Re: Application for improvement permit for Taylor Pointe, lot 9

Health Department file No.07-5-18394

Based on the criteria set out in Title 15A, Subchapter 18A, of the North Carolina Administrative Code, Rules .1940 through .1948, the evaluation indicated that the site is **UNSUITABLE** for a ground absorption sewage system. Therefore, your request for an improvement permit is **DENIED**. A copy of the site evaluation is enclosed. The site is unsuitable based on the following:

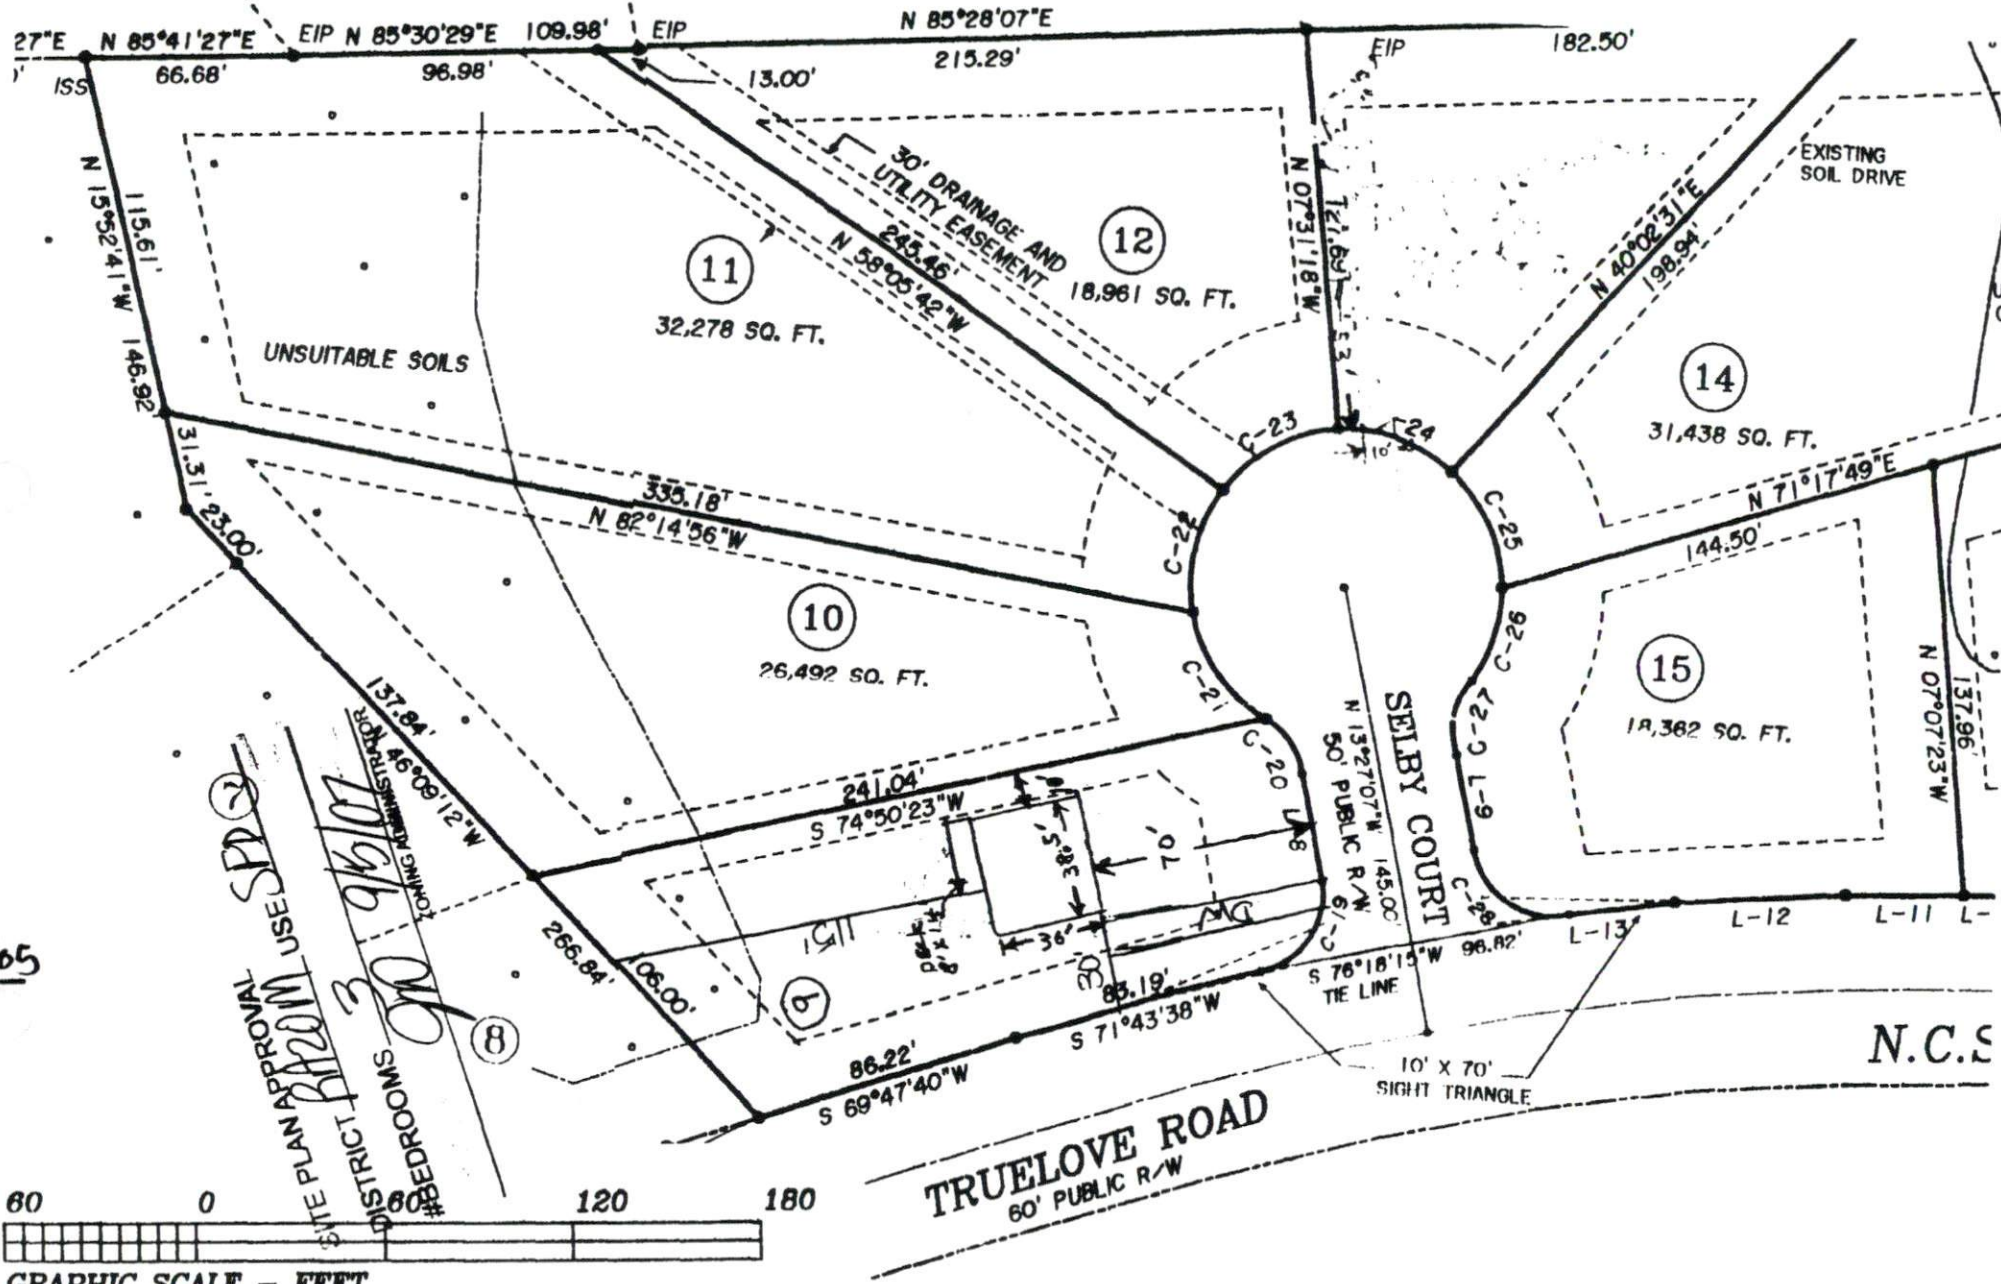
- Unsuitable soil topography and/or landscape position (Rule .1940)
- Unsuitable soil characteristics (structure or clay mineralogy) (Rule .1941)
- Unsuitable soil wetness condition (Rule .1942)
- Unsuitable soil depth (Rule .1943)
- Presence of restrictive horizon (Rule .1944)
- Insufficient space for septic system and repair area (Rule .1945)
- Unsuitable for meeting required setbacks (Rule .1950)
- Other (Rule .1946)

These severe soil or site limitations could cause premature system failure, leading to the discharge of untreated sewage on the ground surface, into surface waters, directly to ground water or inside your structure.

The site evaluation included consideration of possible site modifications, and modified, innovative or alternative systems. However, the Health Department has determined that none of the above options will overcome the severe conditions on this site. A possible option might be a system designed to dispose of sewage to another area of suitable soil or off-site to additional property.

However, the site classified as **UNSUITABLE** may be classified as **PROVISIONALLY SUITABLE** if written documentation is provided that meets the requirements of Rule .1948(d). A copy of this rule is enclosed. You may hire a consultant to assist you if you wish to try to develop a plan under which your site could be reclassified as **PROVISIONALLY SUITABLE**.
